**Consultation Response from KC,
Trees**

2025/90261 York House, 198, Barnsley Road, Denby Dale, Huddersfield, HD8 8TS

Reserved matters application pursuant to outline permission 2022/91024 for demolition of existing works and erection of residential development (3 detached dwellings)

Date Responded: 19/02/2025 *amended on 11/03/2025*

Appendix 6: Arboricultural Implications Plan

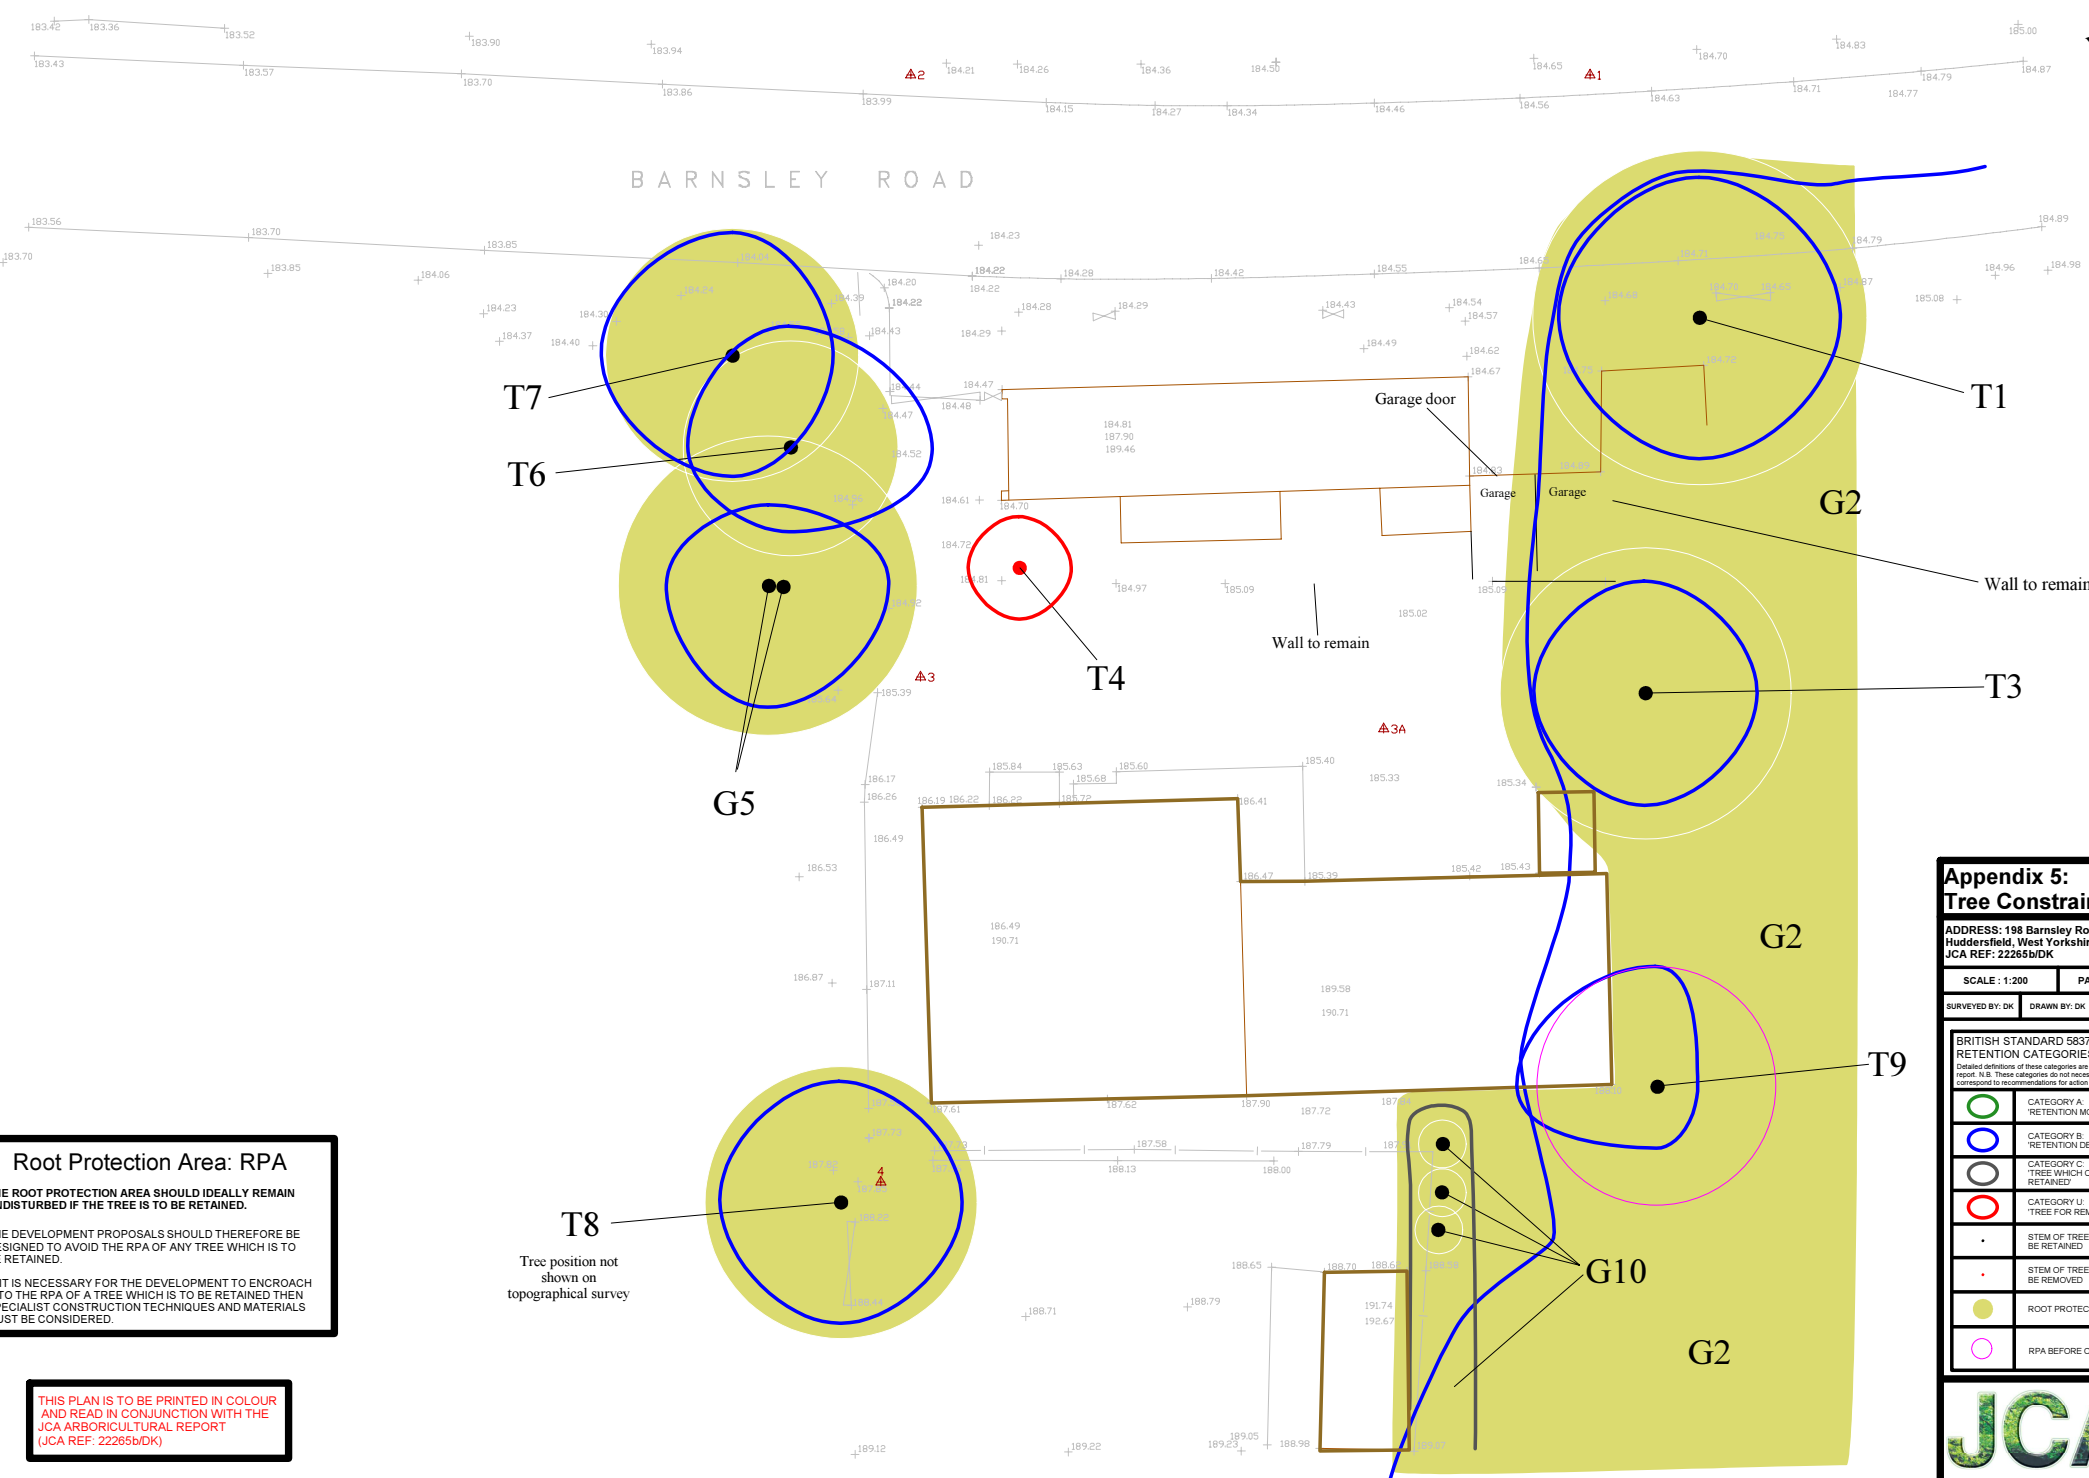
The AIA (ref: 22265b/DK) shows that most of the surveyed vegetation would be retained and incorporated into the landscaping of the development. However, the proposals require the removal of T8 (Cat B) and the removal of a section of protected tree group G2.

Although it may be possible to retain the protected tree, T3 (Cat B) through the development of the site, it is unreasonable for the dwelling at Plot 3 to be erected in such proximity to T3. T3 is semi-mature sycamore and has the potential to grow significantly larger. Sycamores are a fast-growing species and typically reach heights of 20-30m and have final crown spreads of 15m-30m. Therefore, the protected tree T3 would face pruning pressures from the residents of Plot 3, and pressure to remove it in the longer term.
